HEARING ACTION POINTS

Application by Chrysaor Limited for an Order Granting Development Consent for the Viking CCS Pipeline Project

Actions arising from the Issue Specific Hearing 3 (ISH3) held on Wednesday 17 July 2024

4.10 Indicative Central Construction Compound Layout

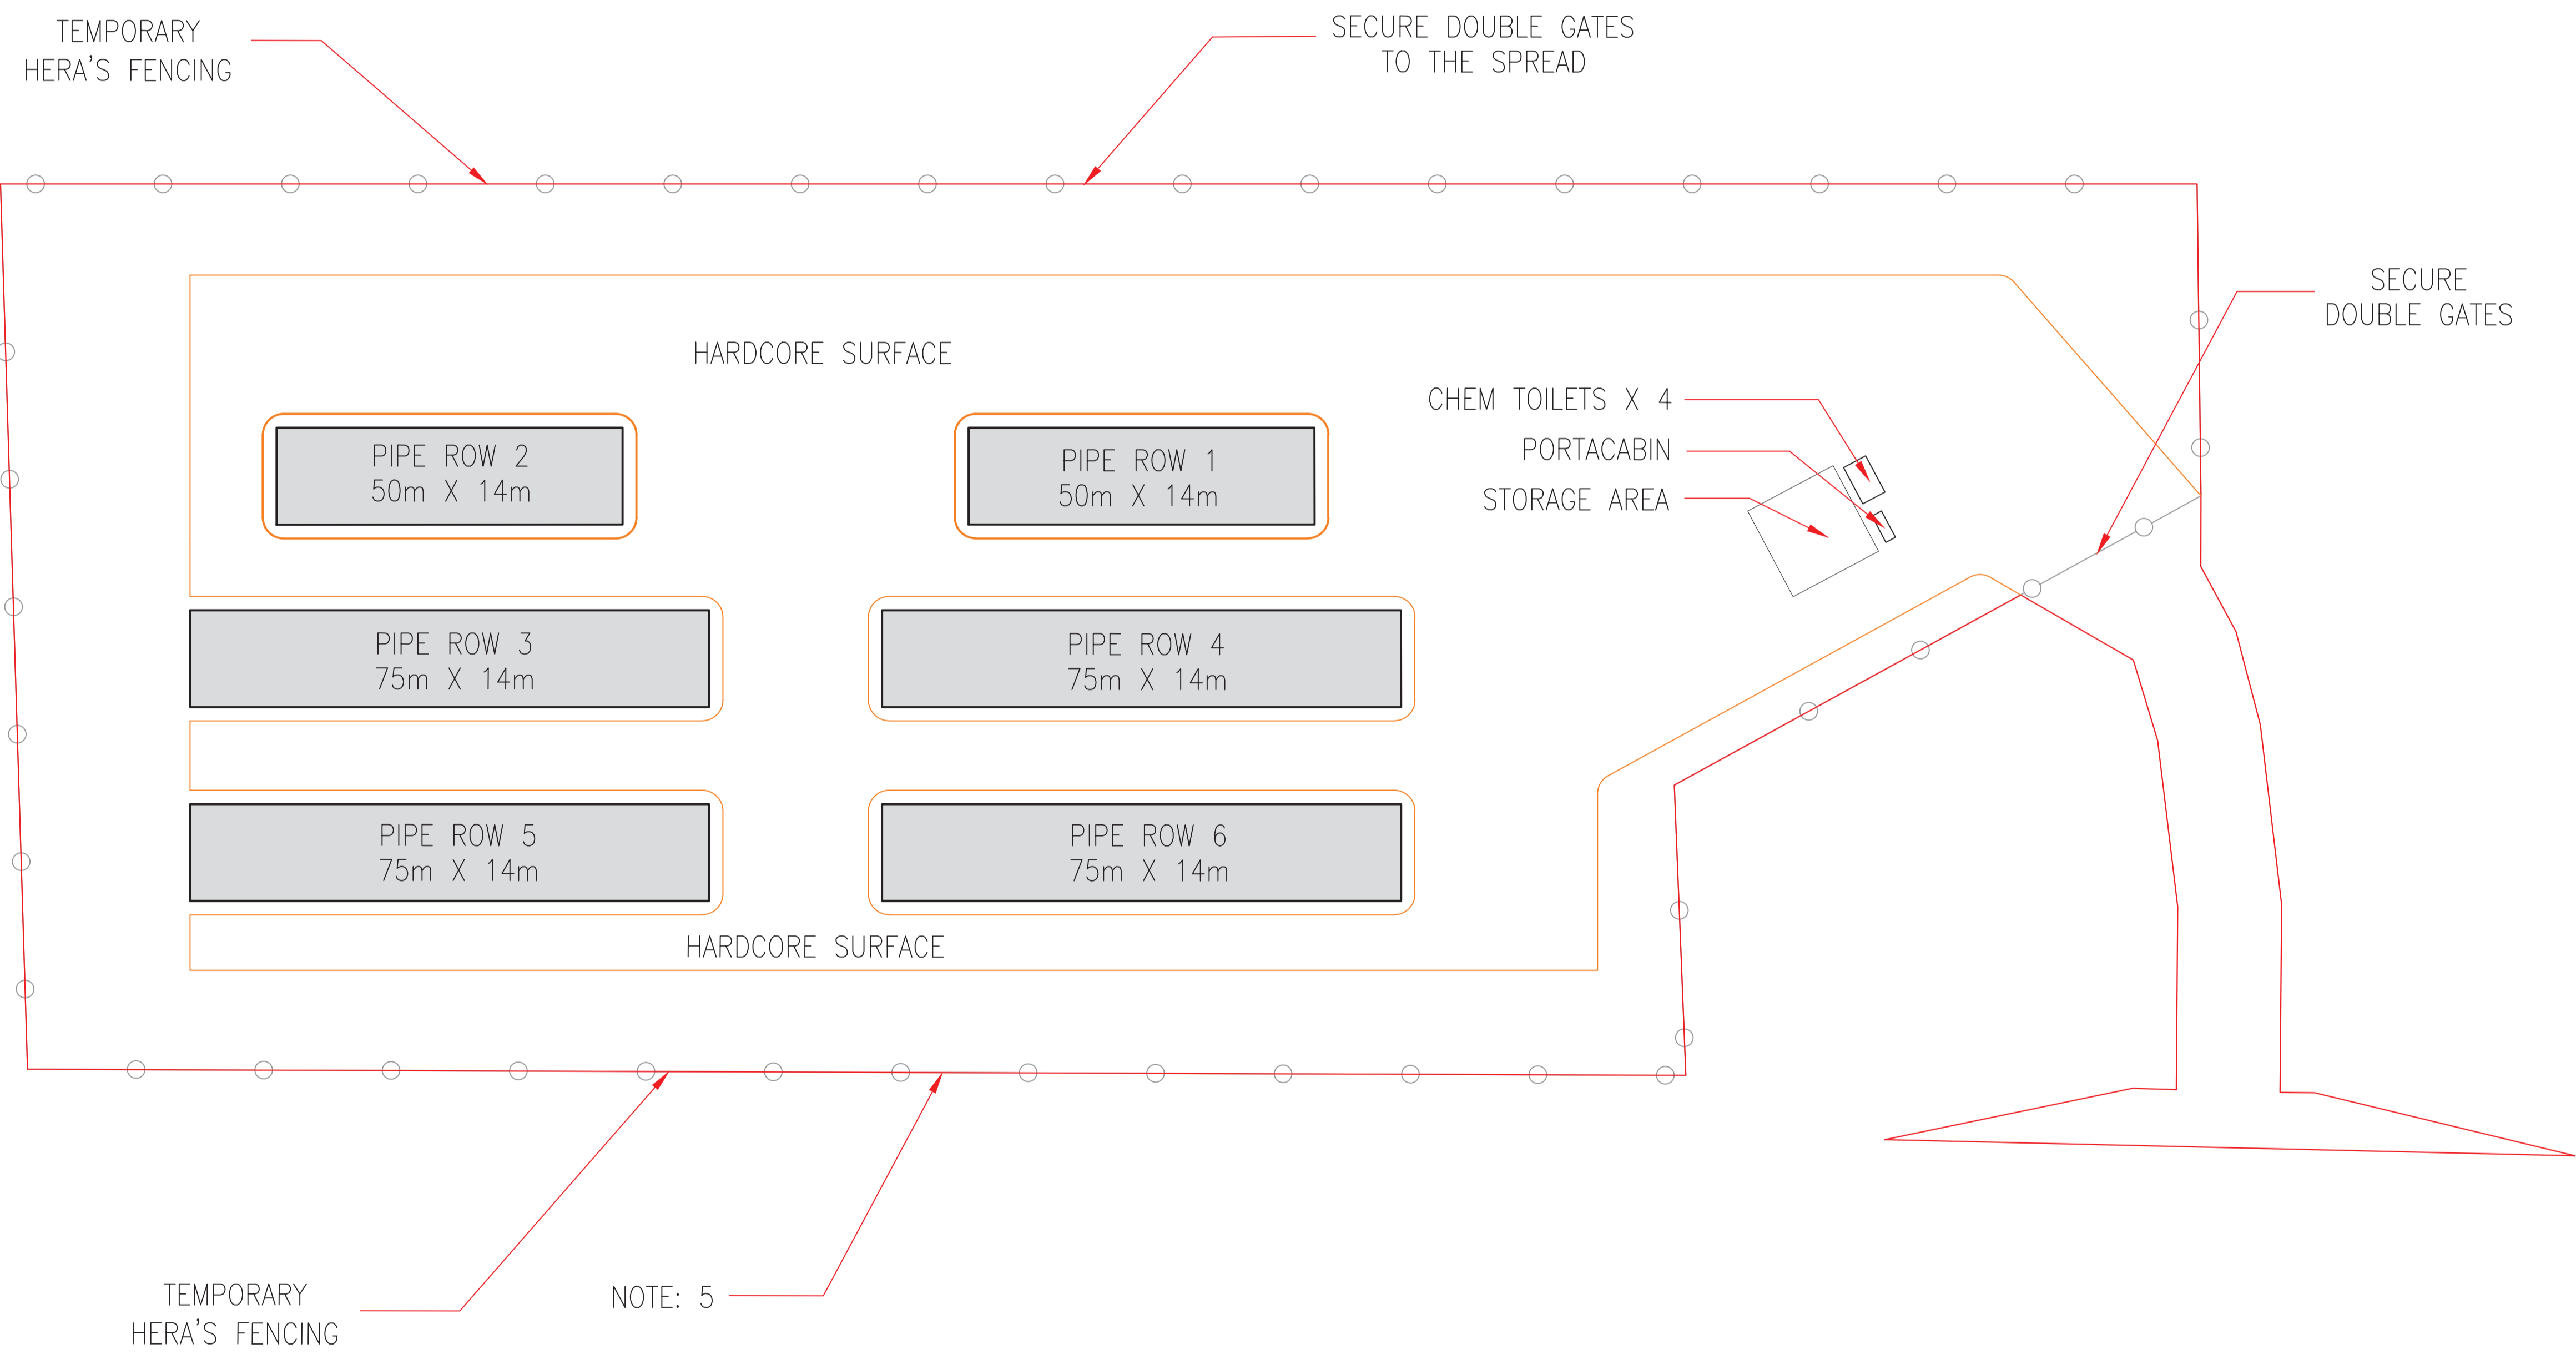
8. Provide a more detailed response concerning the site selection reasons for the central construction compound positioned in the setting of the Area of Outstanding Natural Beauty (AONB).	Applicant	D4

4.14 Washingdales Lane Block Valve Station Plan and Elevations

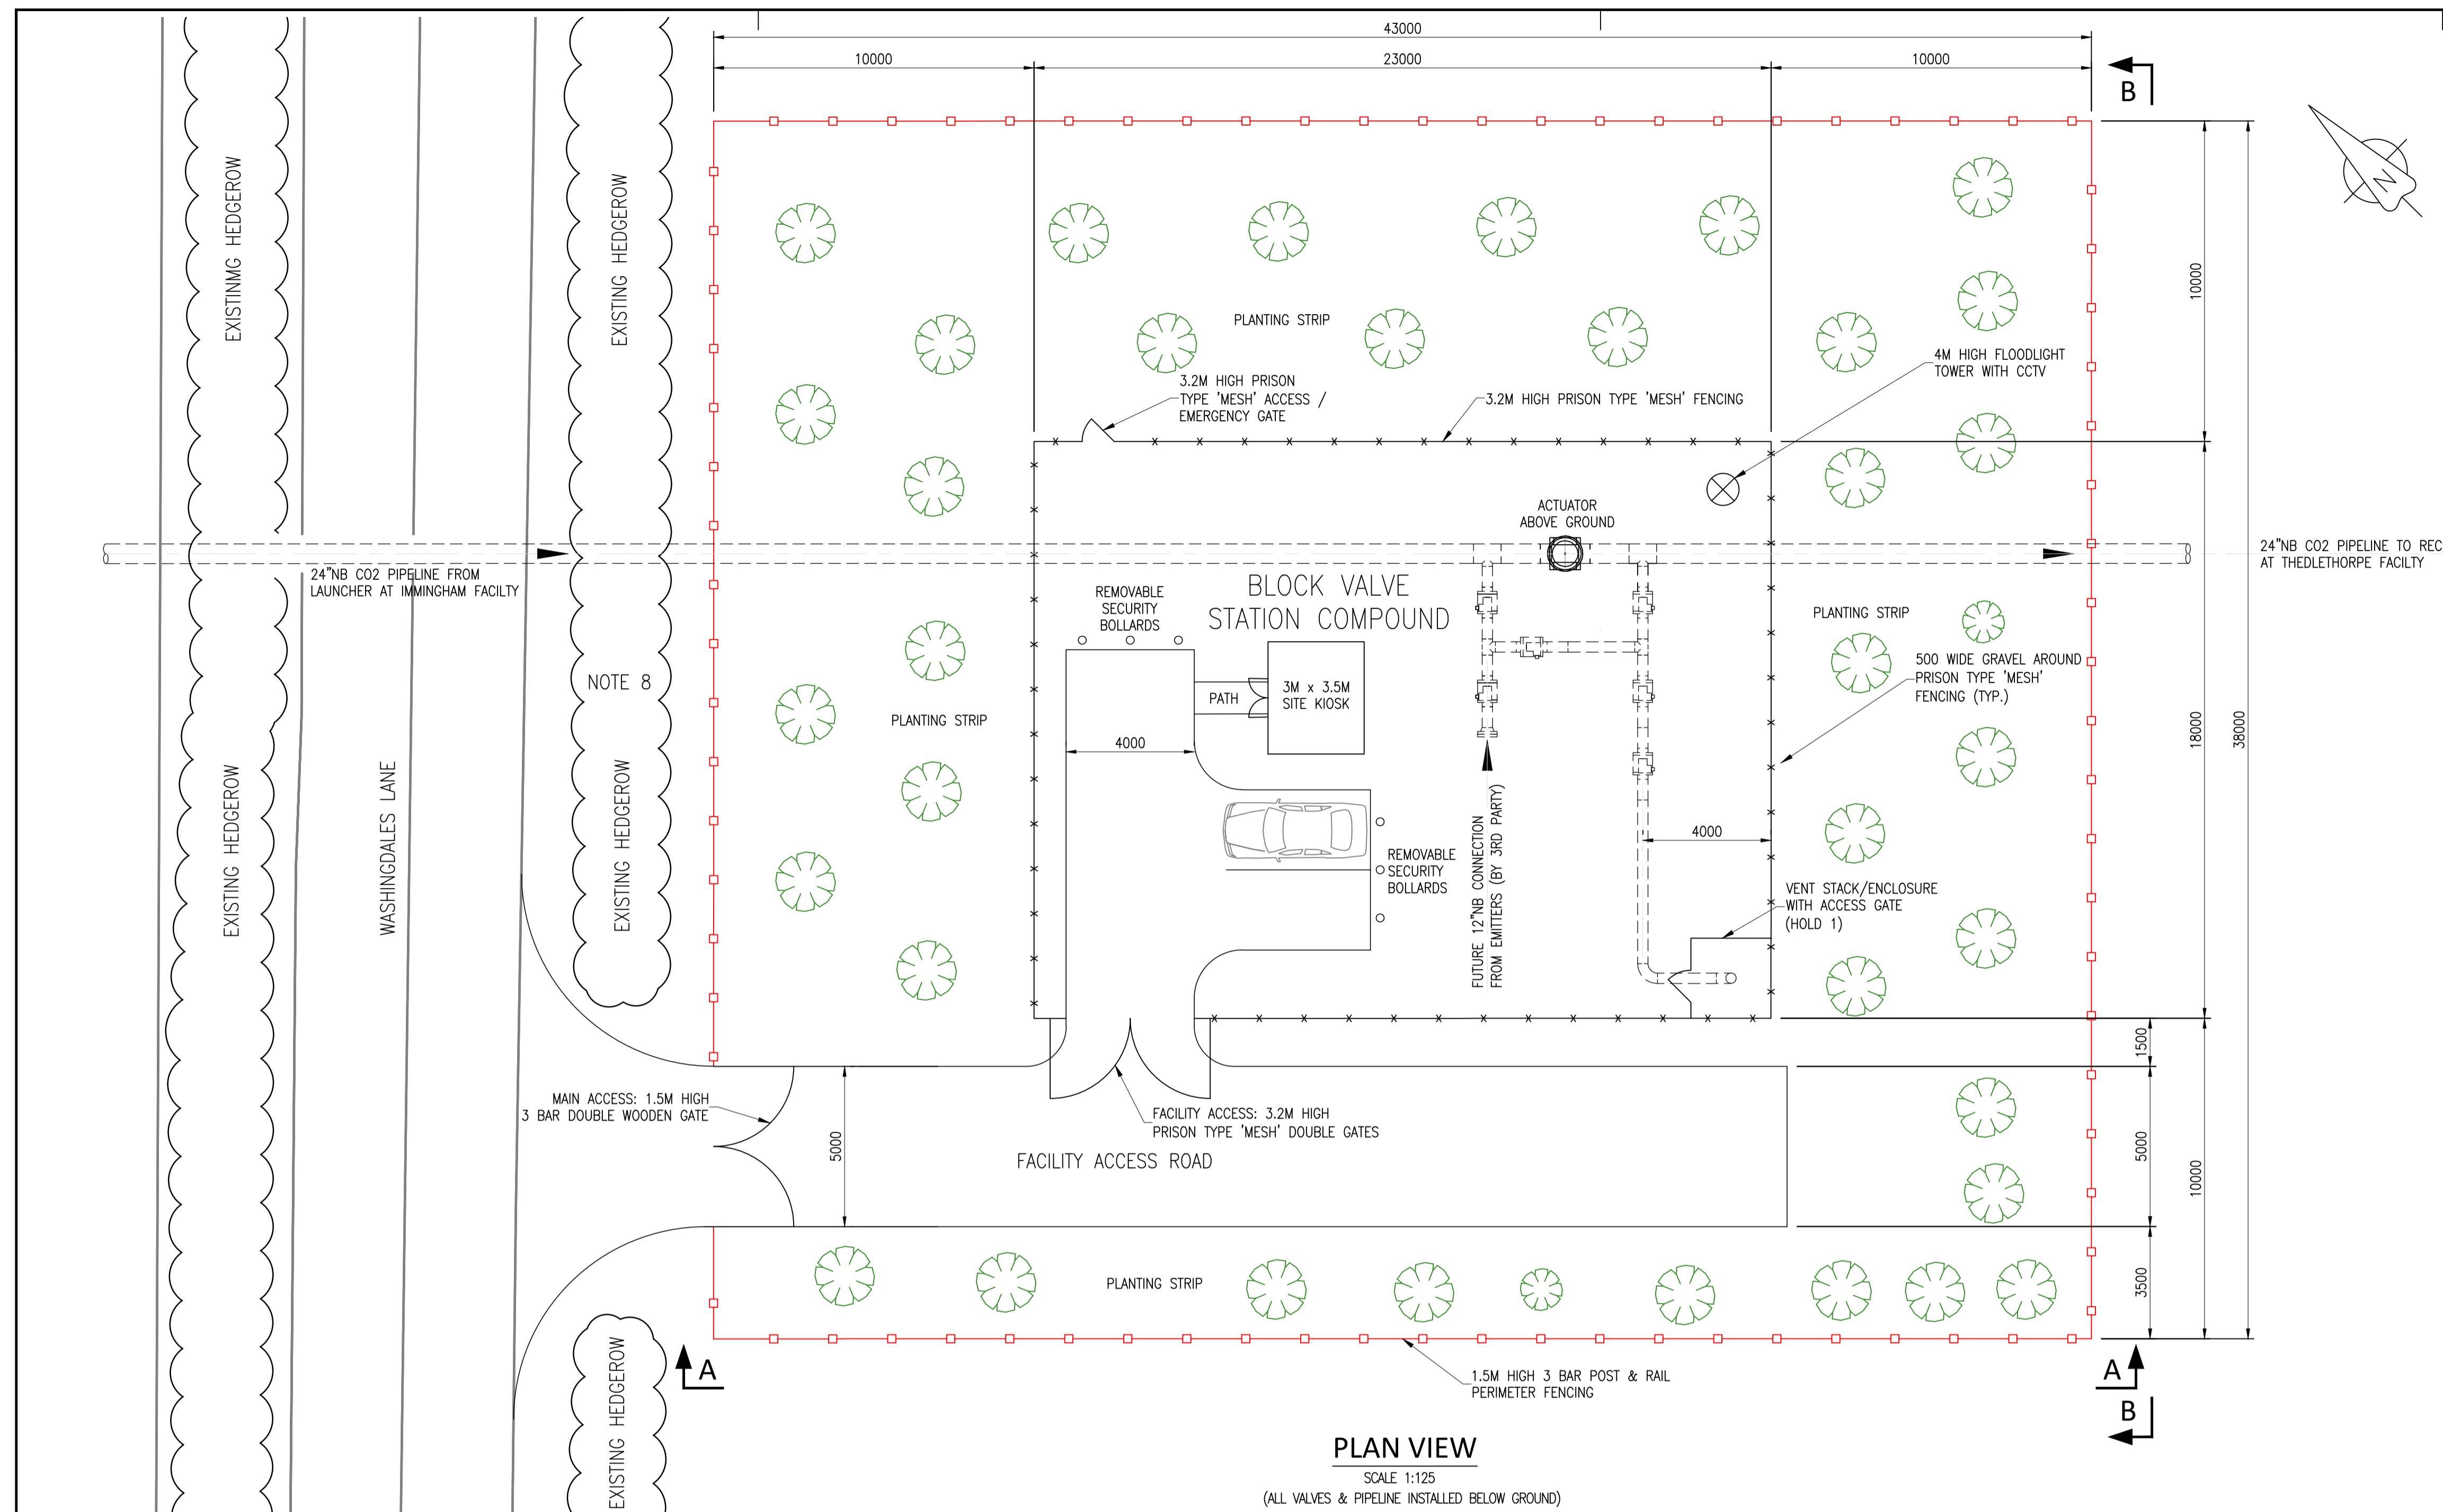
13.	Provide updated illustrative plans to be certified showing the Block Valve Stations without the venting stacks.	Applicant	D4
14.	Provide responses to questions from Examining Authority raised at ISH3 including why they think National Policy Statement for renewable energy infrastructure (EN-3) is relevant to this Application.	Lincolnshire County Council	D4
